Application for a non-material amendment following a grant of planning permission.

PROPOSED CONVERSION OF BARN TO TWO TWO STOREY, THREE BEDROOM DWELLINGS AND ONE THREE STOREY, FOUR BEDROOM DWELLING WITH ASSOCIATED LANDSCAPING, OUTBUILDINGS AND PARKING.

24-0530

The following proposed non-material amendments to the Approved Planning Application Drawings which are minor elevation changes to windows, doors and the main entrance roof (East Elevation) and Main Entrance Lobby re-positioned.

DRAWING TITLE			
PROPOSED NORTH & SOUTH ELEVATIONS			
DRAWN	ERA	REVISIONS	DRAWING No.
DATE	20/04/2026	P1P2	AR/P01
SCALE	1:100/1:50/1:20 @ A1

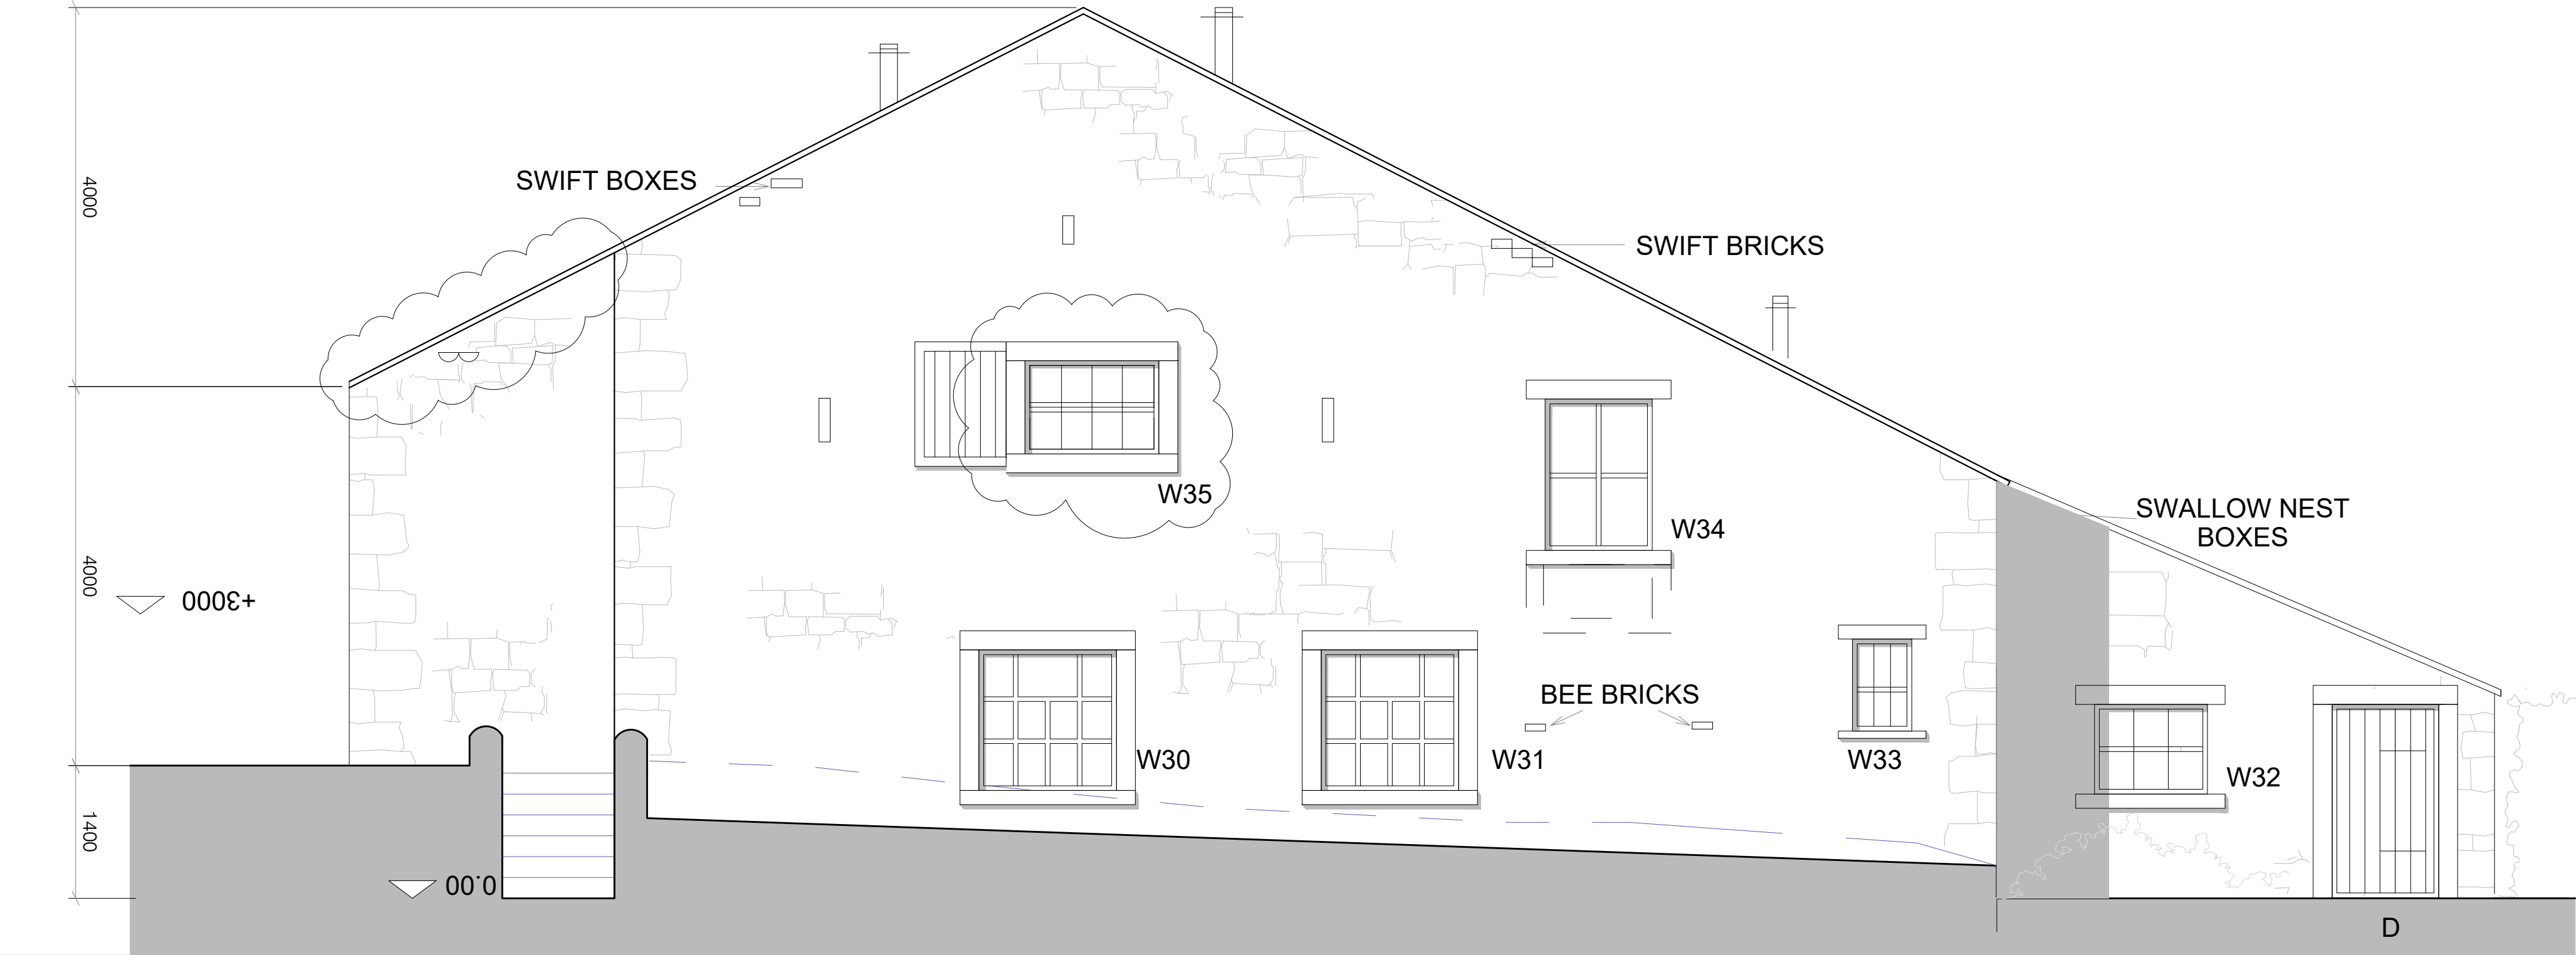
- Windows with revision clouds have been increased in width to 1500mm wide
- East Elevation Main Entrance - the existing roof has been extended to infill over the re-located entrance lobby (original plan was drawn incorrectly with this)
- East Elevation Main Entrance & North Elevation Main Entrance Full Height Door & Window Systems to be installed with aluminium curtain walling due to height/structure - samples to be provided - remaining windows to be in timber.

- The proposed non-material amendments will improve the overall final design of the project -
- increased natural light to the rooms where the windows have been increased and look visually better on the elevations
 - East Elevation Entrance works better with the roof extending over it which is how it probably should have been drawn on the original design
 - East Elevation - full height door and window system - due to the height for buildability this is better suited in curtain walling system
